CLEVE HILL SOLAR PARK

STATEMENT OF COMMON GROUND BETWEEN THE APPLICANT AND NATURAL ENGLAND (POST-SUBMISSION)

November 2019
Revision B

**STATEMENT OF COMMON GROUND (SOCG) –
Post-submission**

APPENDIX 1 – WINTERING BIRD NOISE THRESHOLD

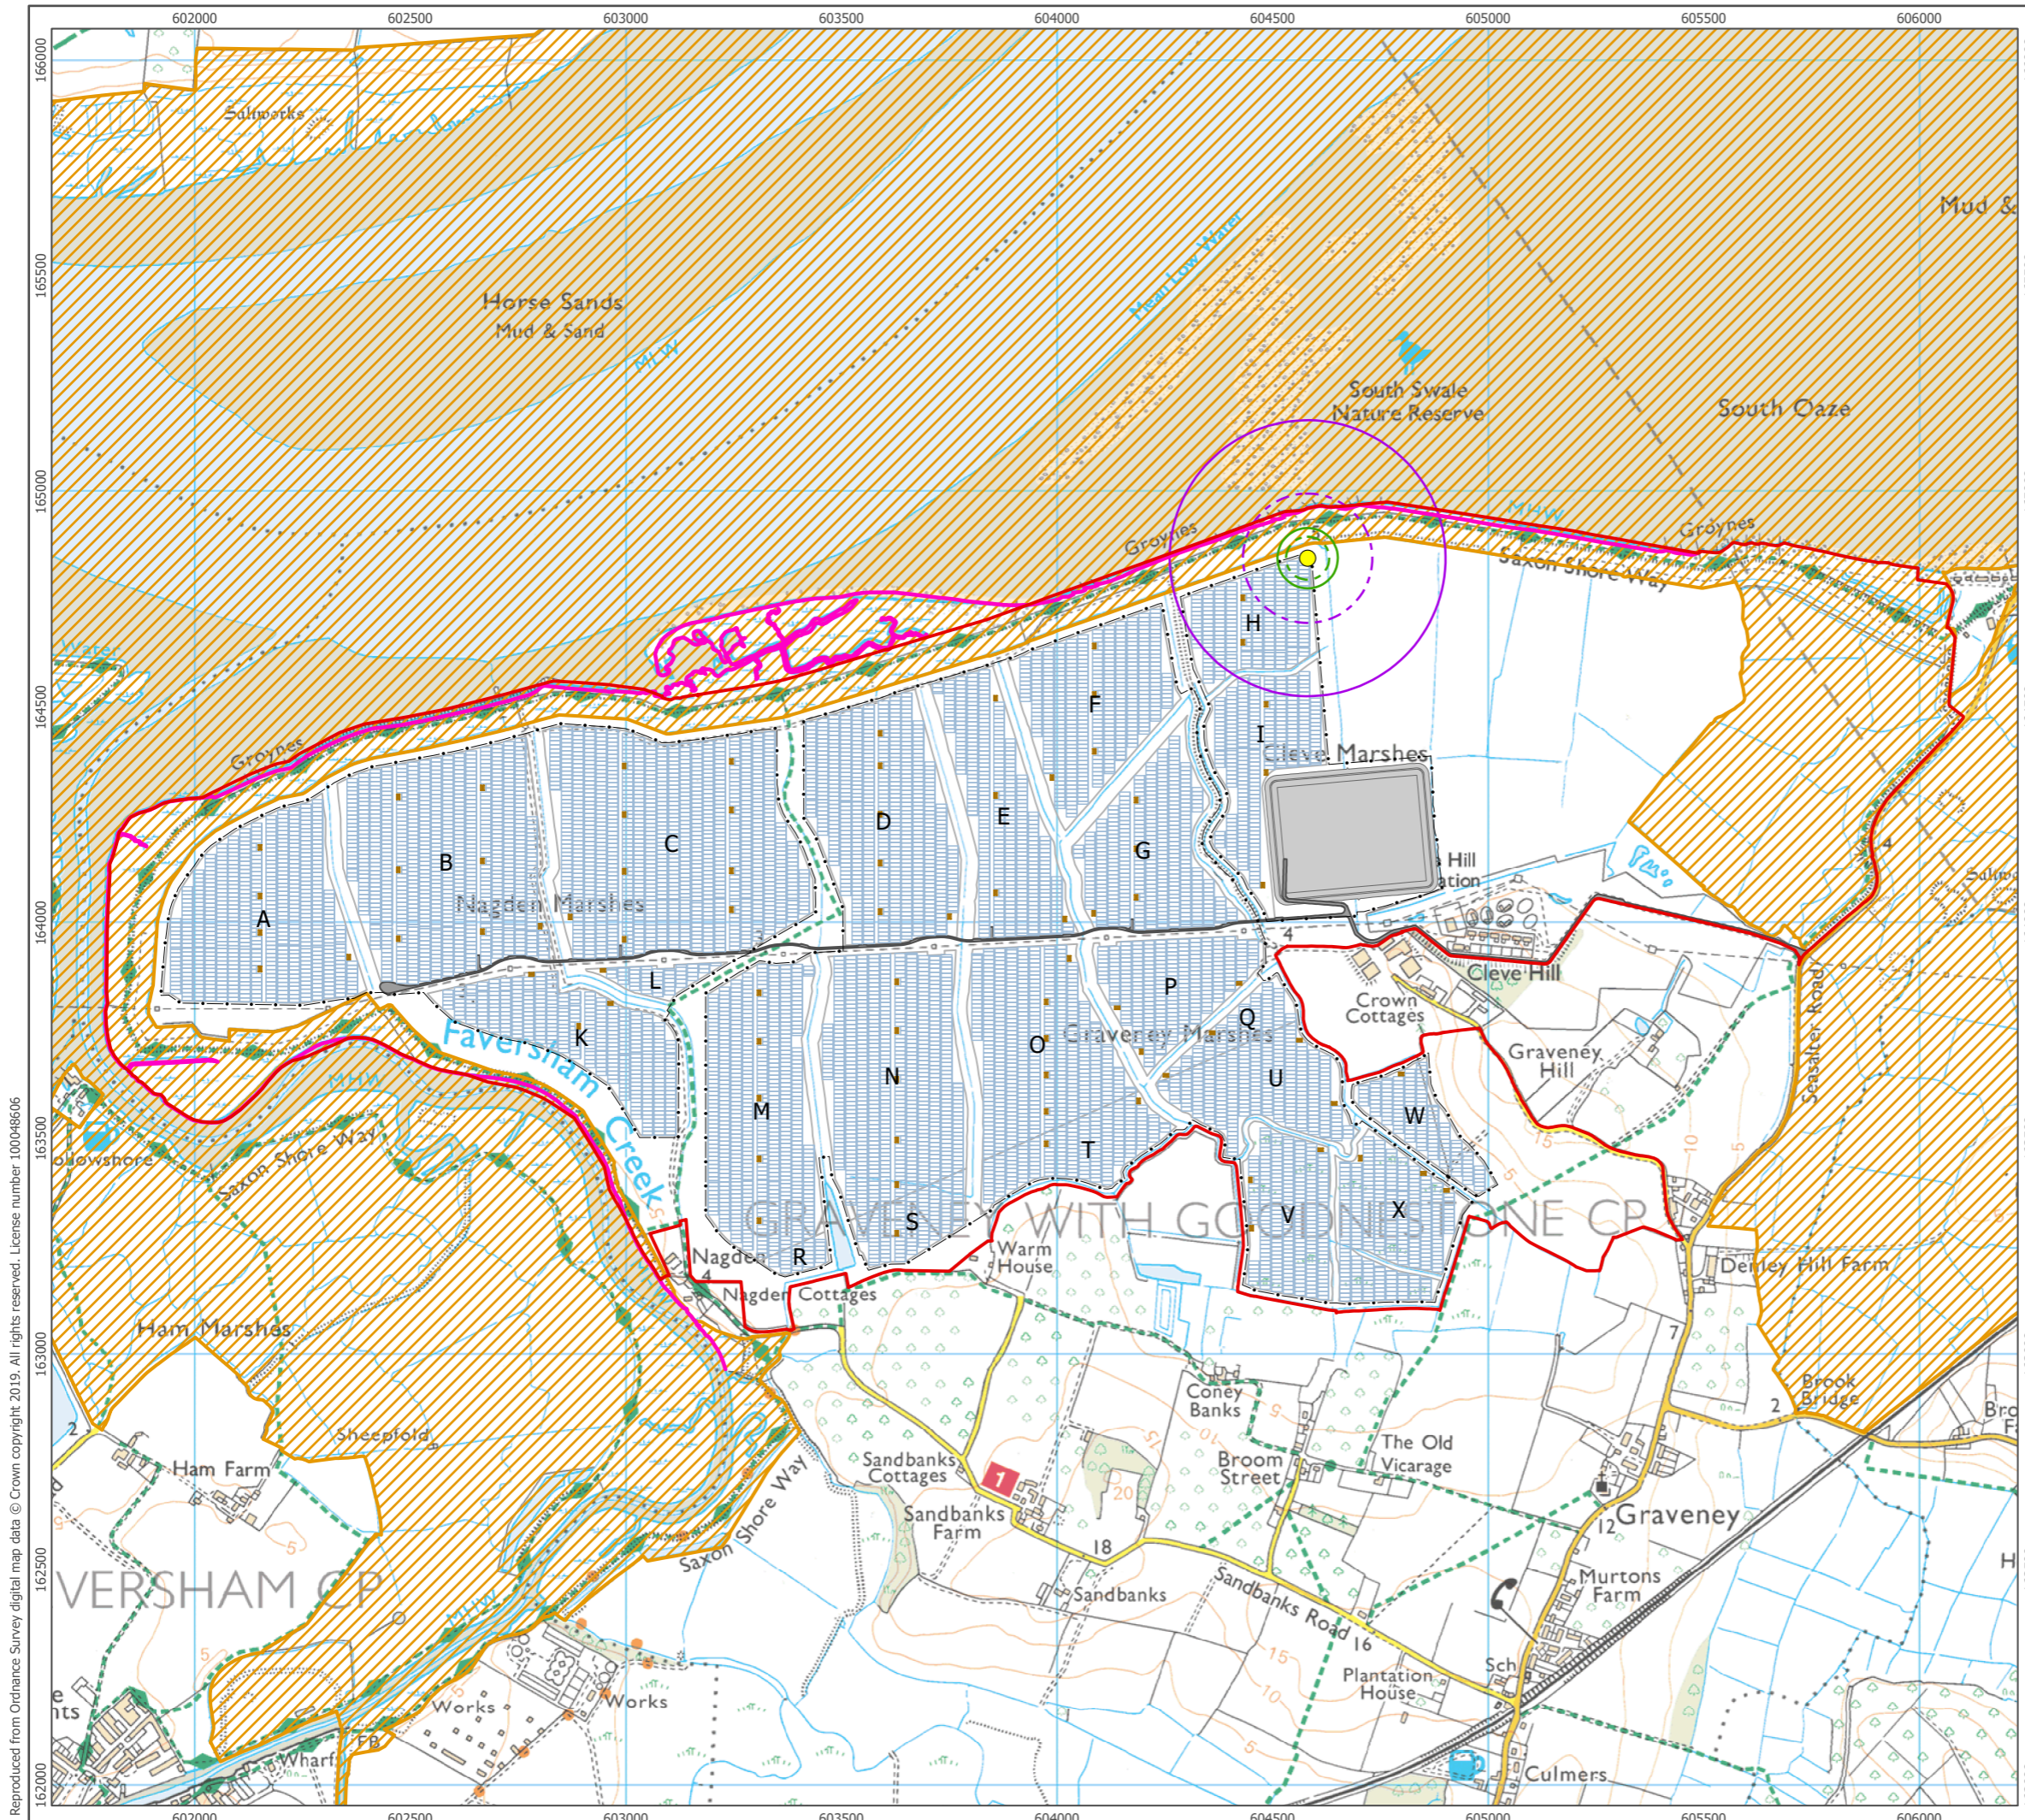
Natural England Comments	Applicant Comments	Status (NE to complete/update)
<p>Figure 3 in the RIAA shows that the 70dB_Lmax noise contour does not reach the intertidal area. However, the 55dB_Lmax contour extends 320m from the source of the piling, and hence extends into the intertidal. Therefore, there is the potential for wintering birds to be impacted. Natural England recognises that only a relatively small proportion of the SPA is affected (paragraph 134 of the RIAA states that 10.6ha of intertidal habitat will be affected when the piling occurs closest to the SPA), and our view is that at low tide this is unlikely to result in an adverse impact. However, the birds of the SPA are more susceptible to disturbance at high tide when they are roosting, as they are confined to smaller areas closer to the source of disturbance and have fewer alternative sites. Therefore, whilst we welcome the mitigation measures set out in the Outline SPA Construction Noise Management Plan (CNMP), we would like to explore whether timing the piling work closest to the SPA, and in particular, close to Castle Coote, outside of high tide, would be possible.</p>	<p>The Applicant will continue to work with Natural England and the Habitat Management Steering Group (HMSG) to reach a satisfactory and workable construction plan to minimise disturbance to roosting birds in the SPA.</p> <p>The outline SPA CNMP [REP3-008] states that the noise levels will be reassessed when plant and manufacturer data become available to ensure that the mitigation mitigates significantly disturbing activity. At such time, additional protections may be included in the SPA CNMP to minimise the risk of significant disturbance to roosting birds in the SPA. Discussions with the HMSG to date have included suggestions such as timing piling works in areas closest to roost sites at Castle Coote during September/October to avoid the core winter season when birds might be more sensitive to disturbing effects, as well as avoiding disturbance within the SPA during the breeding season. Such areas can be defined as the SPA CNMP evolves once more certain data on noise emissions of plant becomes available.</p> <p>The Applicant seeks agreement from Natural England that this approach provides suitable mechanisms to avoid significant disturbance to roosting birds in the SPA.</p>	<p>NE welcomes the inclusion of specific measures in the updated SPA CNMP [REP3-008] to avoid disturbance to wintering birds using Castle Coote, and breeding birds within the SPA. In particular, Appendix 3 showing indicative setback distances, is helpful. We agree that the SPA CNMP contains a sufficient suite of mitigation measures secured in the dDCO,. Therefore, NE can advise that when a formal appropriate assessment is undertaken, the evidence before the Secretary of State is sufficient to support a conclusion of no adverse effect on the integrity of the SPA.</p>

Breeding Bird Noise Threshold
Figure 2

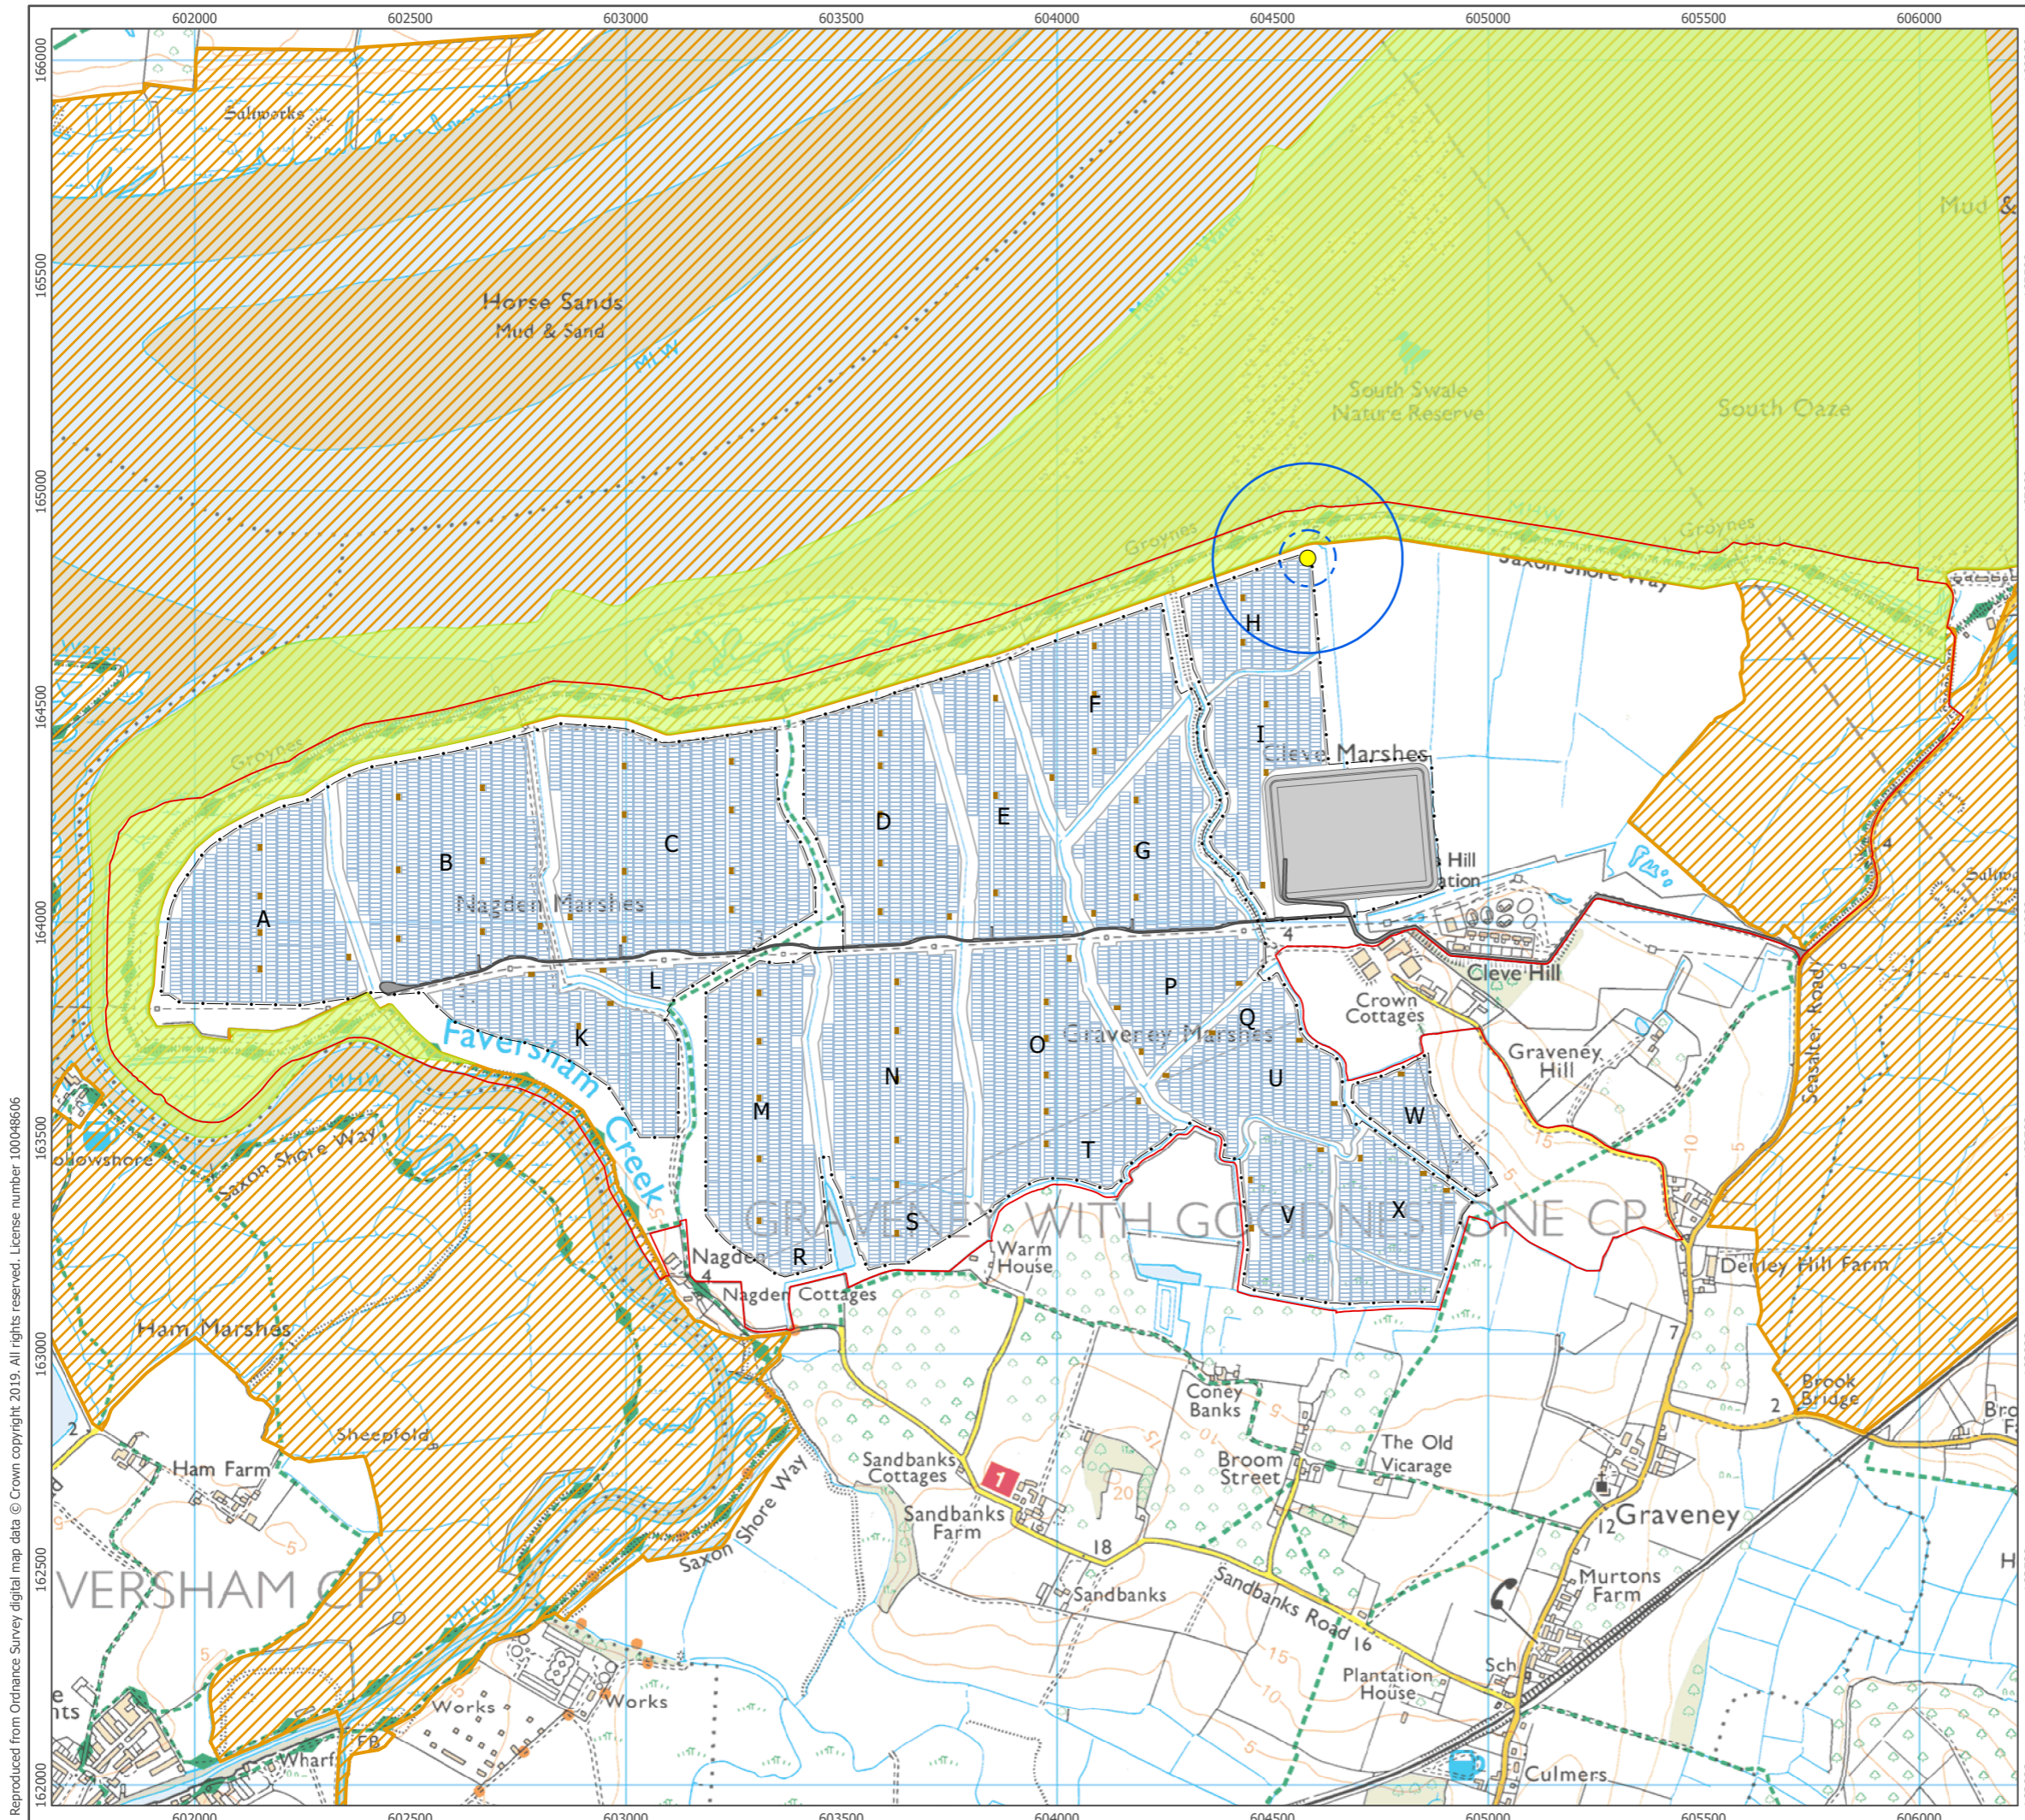
Natural England Comments	Applicant Comments	Status (NE to complete/update)
<p>The grazing marsh and reedbed to the north and west of the solar farm site supports breeding birds which form components of the breeding bird assemblage of the SPA (and SSSI notified features, including bearded tit). These birds are susceptible to disturbance, which may affect their productivity, so mitigation measures are necessary.</p> <p>Paragraph 148 of the RIAA states that construction activities resulting in noise over 65dBLAmax will be avoided in the breeding season (1 March to 31 August inclusive). Whilst we welcome the commitment to avoid disturbance in the breeding season, we question the use of this threshold and whether it provides sufficient certainty over the absence of potential impacts. Natural England will work with the applicant on this point and provide further advice during the examination. Greater clarity is also needed regarding the scheduling for construction, and whether this will enable the threshold mitigation measure to be complied with. This is because the Breeding Bird Protection Plan (Appendix B of the Outline Construction Environment Management Plan (CEMP)) states that 'where practicable' construction activities closest to The Swale will be avoided (paragraph 158), which does not give sufficient certainty.</p>	<p>The Applicant will continue to work with Natural England and HMSG to reach a satisfactory and workable construction plan to minimise disturbance to breeding birds in the SPA and SSSI.</p> <p>Section 9.5.2.1 of Chapter 9: Ornithology of the ES [APP-039] and Section 6.1.1 of the RIAA [APP-026] describe the rationale for setting precautionary thresholds of noise levels for the assessment of effects on birds. These were based on the available literature and the Applicant gave due consideration of the site-specific baseline ambient environment. Based on the assessment of effects, an outline SPA Construction Noise Mitigation Plan (SPA CNMP) [REP3-008] has been developed together with the Breeding Bird Protection Plan (BBPP, Appendix B of the outline CEMP [REP6-007]) to minimise the risk of significant disturbance to birds.</p> <p>In paragraph 158 of the BBPP in the outline CEMP, the term 'where practicable' was intended so as not to restrict <u>all</u> construction activities in areas closest to the SPA boundary during the breeding season. It is necessary to permit activities that do not cause noise emissions exceeding the threshold described in the assessment – such activities may be required for the efficient execution of the development's construction and would be no more disturbing to breeding birds than the typical baseline farming operations. Section 6 of the outline SPA CNMP describes the measures, including implementation of appropriate setback distances for piling and other noisy construction</p>	<p>NE agrees that the mitigation measures set out in the updated SPA CNMP [REP3-008] and within the updated Breeding Bird Protection Plan at Appendix B of the CEMP [REP6-007] are sufficient such that NE can advise that when a formal appropriate assessment is undertaken, the evidence before the Secretary of State is sufficient to support a conclusion of no adverse effect on the integrity of the SPA.</p>

Natural England Comments	Applicant Comments	Status (NE to complete/update)
	<p>activities activities, to be implemented to ensure that the noise levels at the SPA boundary will not exceed 65 dB L_{Amax} during the breeding season. The wording of the BBPP in the outline CEMP will be reviewed and discussed with Natural England to provide greater clarity and certainty in this respect.</p> <p>An ECoW will also be deployed during the construction phase to observe bird responses and inform further action in order to prevent significant disturbance. The BBPP applies additional protective measures for marsh harrier, which is considered to be the species likely to be most sensitive to disturbance.</p> <p>The Applicant seeks agreement from Natural England that this approach provides appropriate mechanisms and certainty to avoid significant disturbance to breeding birds in the SPA.</p>	
<p>Natural England is satisfied that the construction traffic using the site access road adjacent to the SPA grazing marsh to the east of the development site will not cause significant disturbance to the birds using that part of the SPA in the breeding or wintering seasons.</p>	<p>This is agreed.</p>	<p>Agreed.</p>
